**Application Reference:** 2025/0877

Fox and Hounds, Pontefract Road, Shafton, Barnsley, S72 8QP

This application seeks full planning permission for the conversion of former public house to a retail shop on ground floor. The plans have been amended during the course of the application to remove the proposed residential element at first floor and an alteration of the parking to the frontage of the site.

1 -Proposed Front Elevation
1 : 100

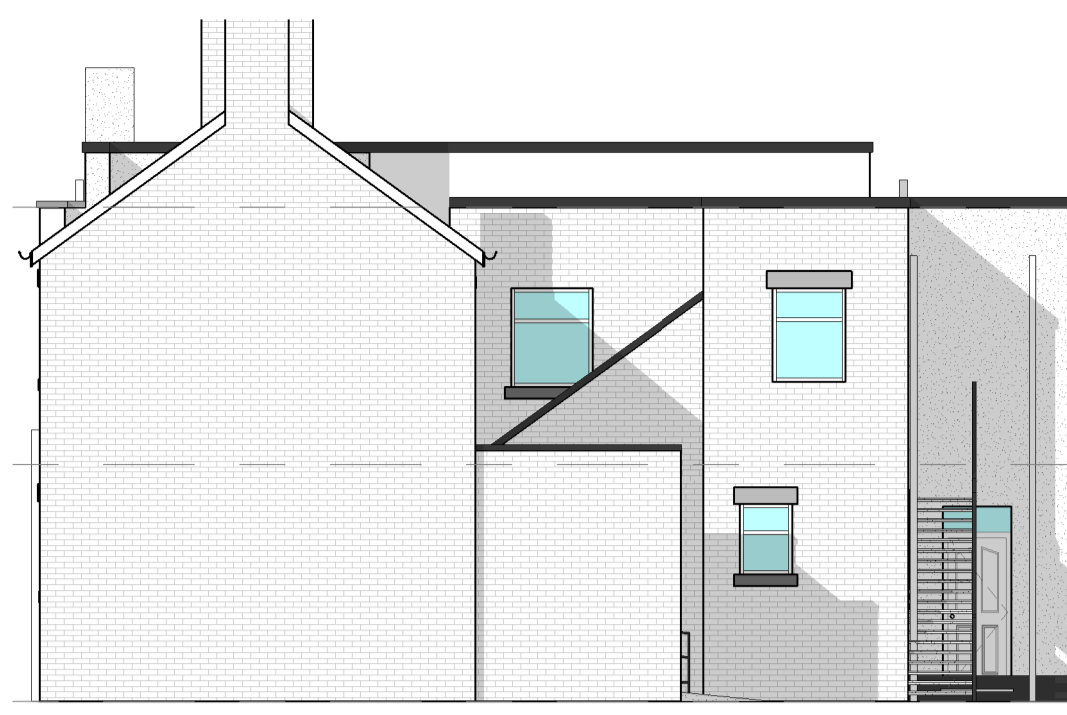
The proposal involves the replacement of the frontage of the building with a glazed shop front, no other alterations are proposed, with a general refurbishment of the building. The proposal would improve the appearance of the vacant building with new glazing and courtyard parking area. Overall the proposal is acceptable in terms of visual amenity and design and in accordance with Local Plan Policy D1. The improved visual amenity and impact upon the street scene is considered to be significant.

-Proposed Parking Plan
1 : 100

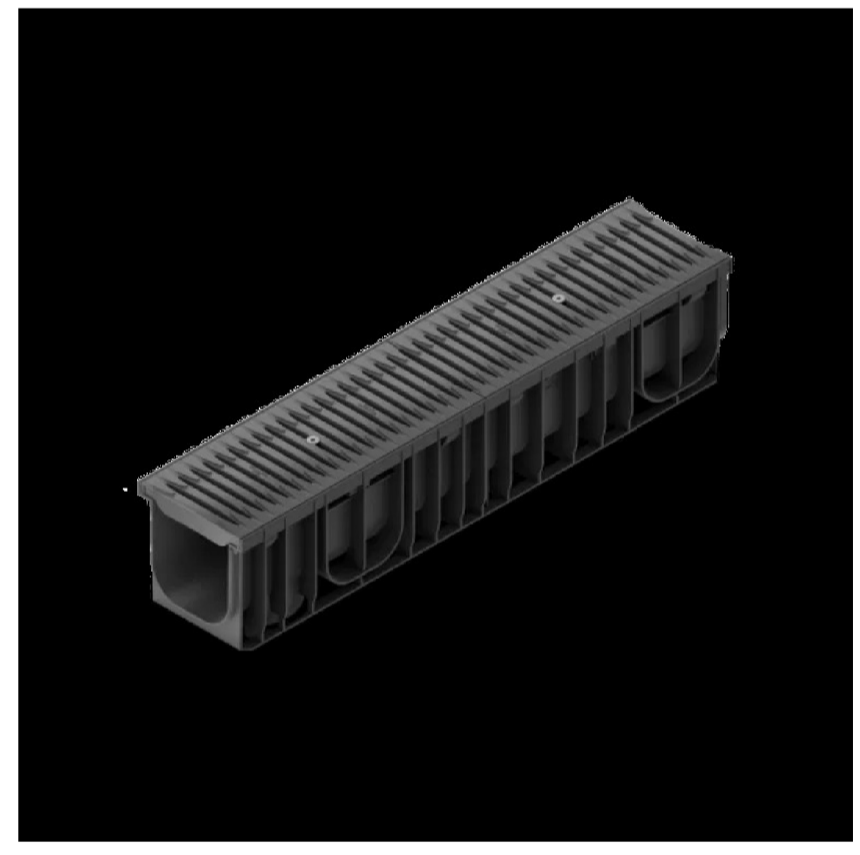
Concerns have been raised by residents with regard to a lack of parking at the site, conflict with adjacent uses and intensification of the use on the site and its impact upon Highway Safety. The site is located within Shafton in a predominantly residential area, served from Weetshaw Close which is a blocked cul de sac with no through route. The Highways Officer originally raised concerns with regard to the extent of the initial proposal, with the proposed 3 bed apartment at first floor, together with the shop use and lack of parking/servicing arrangements. The plans have been amended and the Highways Officer has been consulted on the amended proposal, which includes the removal of the first floor residential accommodation and the addition of 4 parking spaces to the site frontage. The Highways Officer has stated that 'Further to the applicant's recent submission of an amended layout drawing and Parking Statement, the parking provision for the proposed use has increased to 4 spaces, of adequate size (5mx2.5m) in accordance with the requirements set out within Barnsley's Parking SPD.

The applicant has also confirmed that deliveries will be carried out via a staff member to a cash and carry and as such no large vehicles are expected.' There is currently a low wall along the site boundary where the new parking area is proposed and Highways would expect this to remain in situ to prevent vehicles from accessing or egressing directly from Pontefract Road.

Given the amended layout and increase in parking provision, the Highways Officer has no objections to the proposal and there should be no significant impact upon highway safety in accordance with policy T4 of the Local Plan and the Parking SPD. As a result the impact upon Highways is considered to be moderate.
